KIRKLEES METROPOLITAN COUNCIL INVESTMENT & REGENERATION SERVICE

DELEGATED DECISION TO DETERMINE APPLICATIONS FOR CONSENT, AGREEMENT OR APPROVAL REQUIRED BY CONDITION

Reference No:	2026/44/91475/W
Site Address:	adj, Huddersfield Open Market, Brook Street, Huddersfield, HD1 1RY
Description:	Discharge of details reserved by conditions 6 (bin storage), 7 (crime) on previous permission 2025/93197 for erection of free standing single storey structure to be used as temporary indoor market (sui generis) with associated facilities, office cabins, waste compound, parking spaces and works (within a Conservation Area)
Recommending Officer:	John Holmes

APPLICATION SEEKING DISCHARGE OF CONDITION – 2026/91475

Waste Management Proposal Diagram

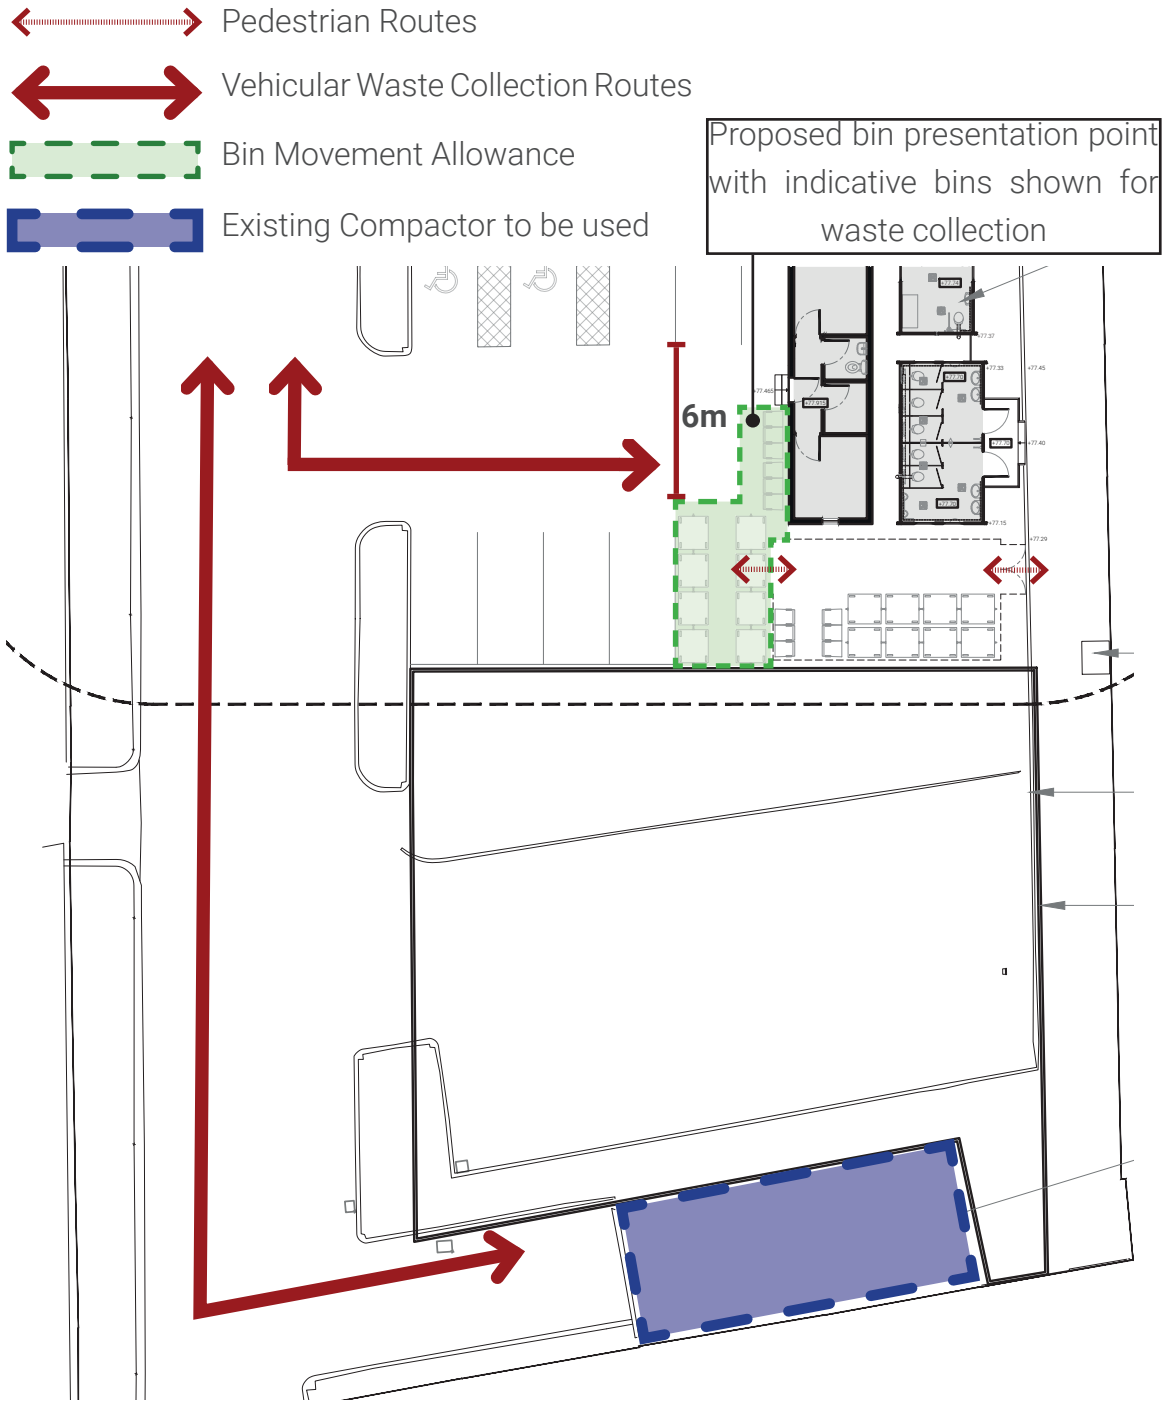
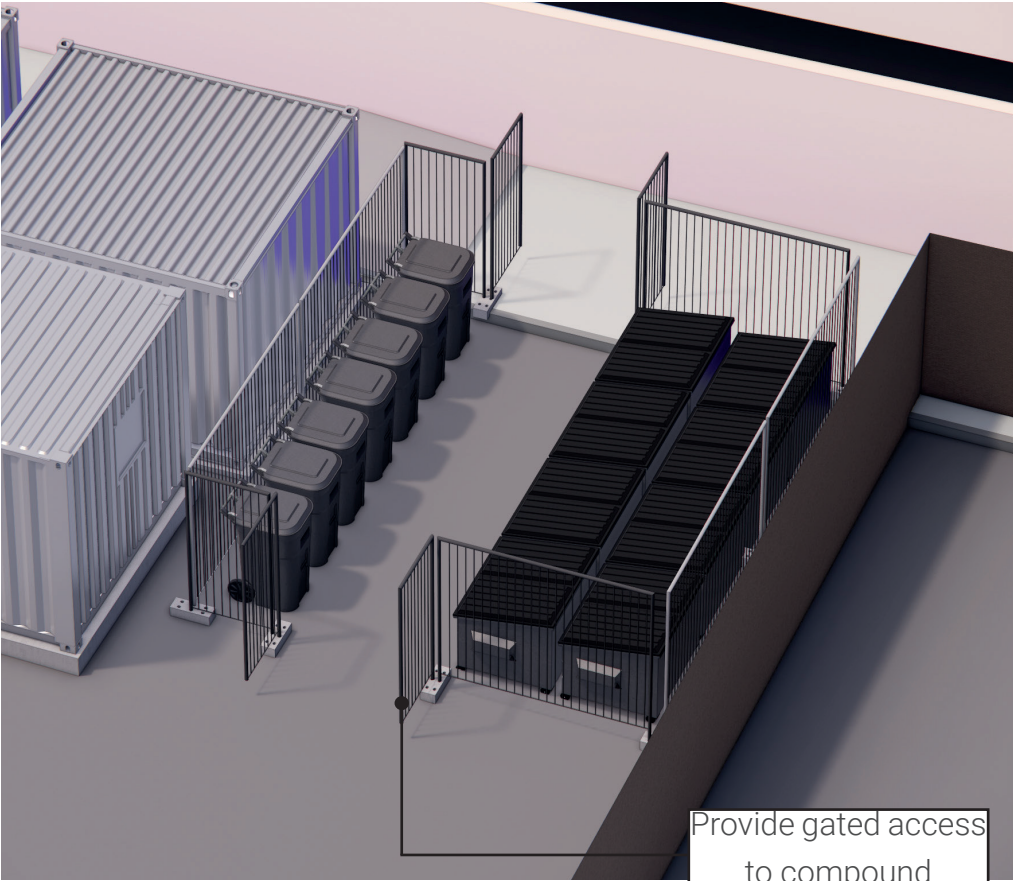
(ii) The waste collection presentation point is located to the front of the bin storage compound meaning that drag distances are kept to a minimum and access to the collection point can be made by a refuse collection vehicle (swept path analysis was provided as part of application 25/93197 in drawing No C121 P01) and this would be acceptable, however the collection point requires a refuse vehicle to reverse through a public car park and as servicing is limited to 9am to 4pm, this would need to be done while the car park is attracting a peak demand and this would be a highway safety concern.

We would like to see the collection point relocated away from the car park and would suggest that it is moved to adjacent to the compactor to the south of the site. This would increase the drag distance that the Market Management team would have to move the bins on collection day, however as there is no reason for vehicles or pedestrians to be within the area to the front of the compactor, HDM consider this a safer location for temporary collection.

With this we cannot currently support the discharge of condition 6 on highway safety grounds, however if the collection point can be relocated to remove the requirement for a refuse wagon to need to reverse through a public car park, we may be able to re-assess the application with a more positive outcome.'

The location of the waste storage area is to a part of the site where such storage areas would typically be expected to be seen given it is in proximity to existing such facilities. The waste storage is sited a suitable distance from neighbouring occupiers such that it is considered that adverse impacts from noise / odour would not arise.

The requirements of condition no.6 for the location, design and materials of all bin storage areas/enclosures and recycling storage areas for the development and bin presentations points for collection of wastes has been satisfied by the scheme which has been submitted.

It is therefore recommended that condition no.6 be discharged.
